Appeal Decision

Appeal Ref: APP/R5510/D/24/3337868

48 Pole Hill Road, Uxbridge UB10 0QB

- The appeal is made under section 78 of the Town and Country Planning Act 1990 (as amended) against a refusal to grant planning permission.
- The appeal is made by Mr Syed Hussain against the decision of the Council of the London Borough of Hillingdon.
- The application Ref. is 33924/APP/2023/2780.
- The development proposed is the erection of a part single, part double storey rear extension.

Q| PROPOSED FIRST FLOOR PLAN

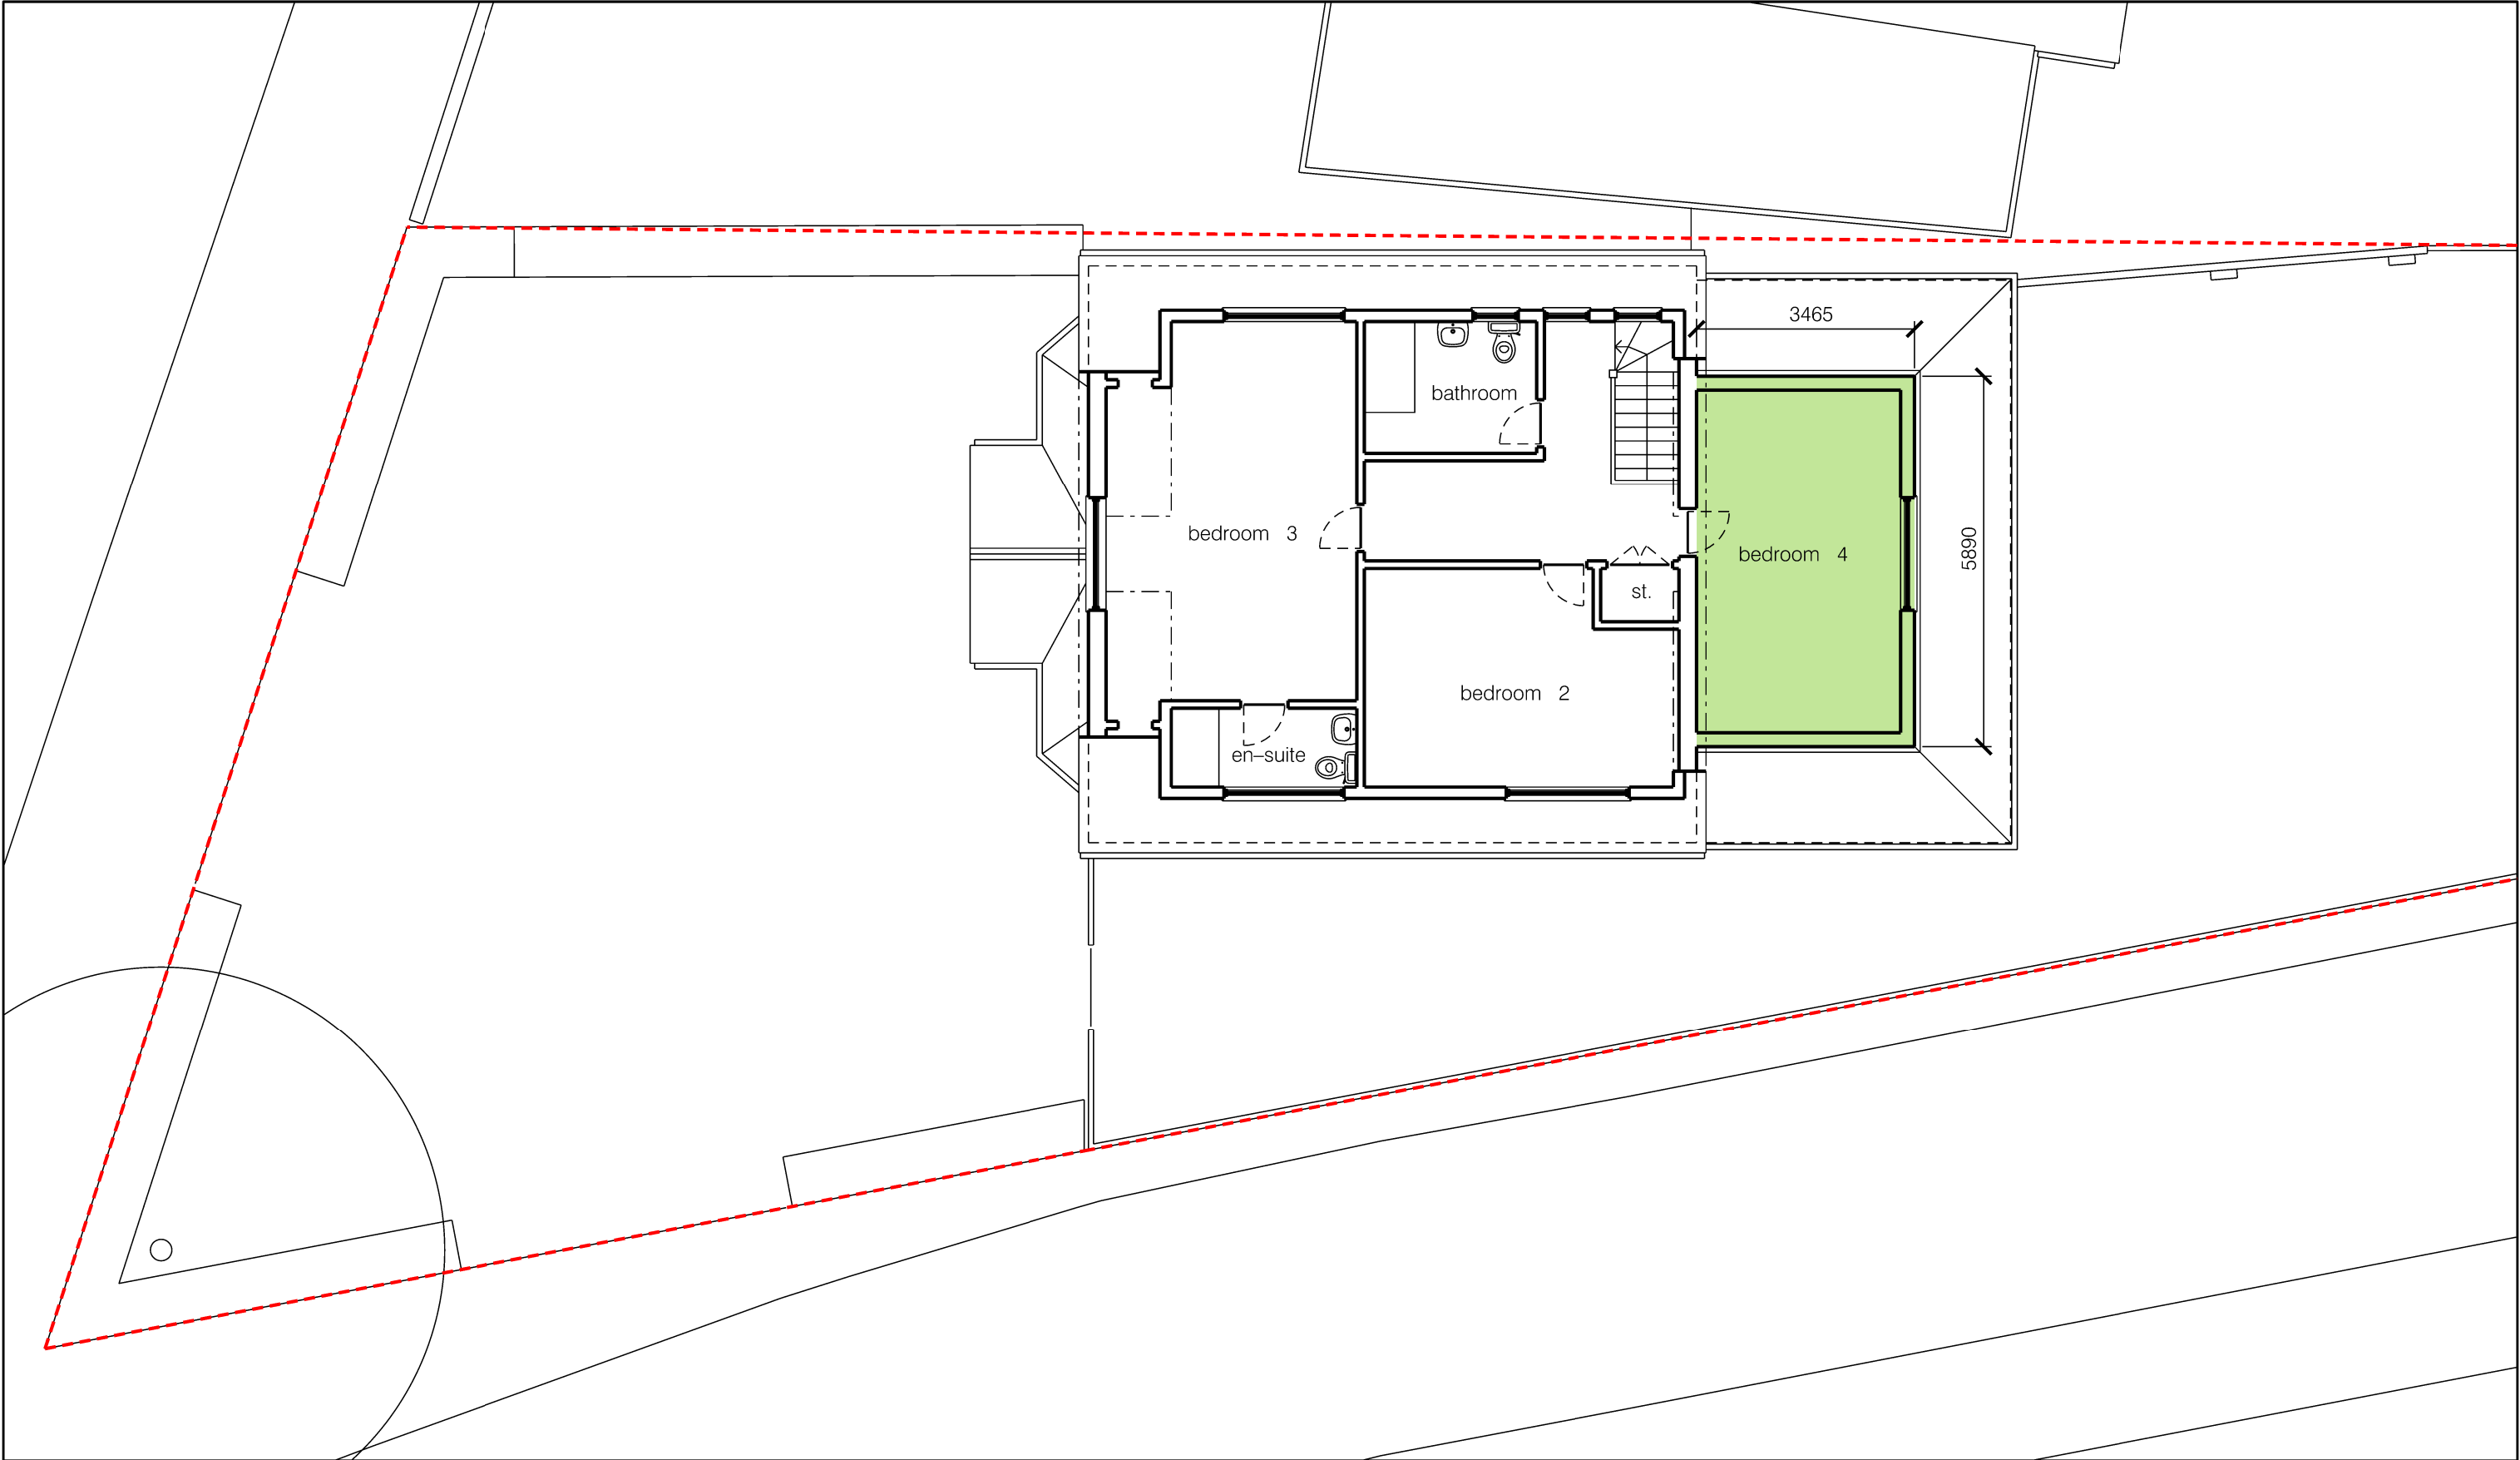
6. The proposed first floor rear extension would be at roof level as the property is a bungalow. It would measure about 3.45m in depth and about 5.90m in width and be about 5.30m from ground level. The drawings show the roof being flat and the first floor extension sitting on the ground floor extension which has a 3 sided pitched skirt roof wrapping around it.

7. Whilst the proposed first floor element of the rear extension would not exceed the height of the main roof ridgeline and the proposed dormer would be of a width that would allow part of each side dormer cheek to be seen, it would, nevertheless, exacerbate both the box-like appearance of the dwelling and its top-heavy appearance. It would also mask the rear gable which is a valuable remaining defining characteristic of the original bungalow. Overall, it would be a poor, overdeveloped and inharmonious design.
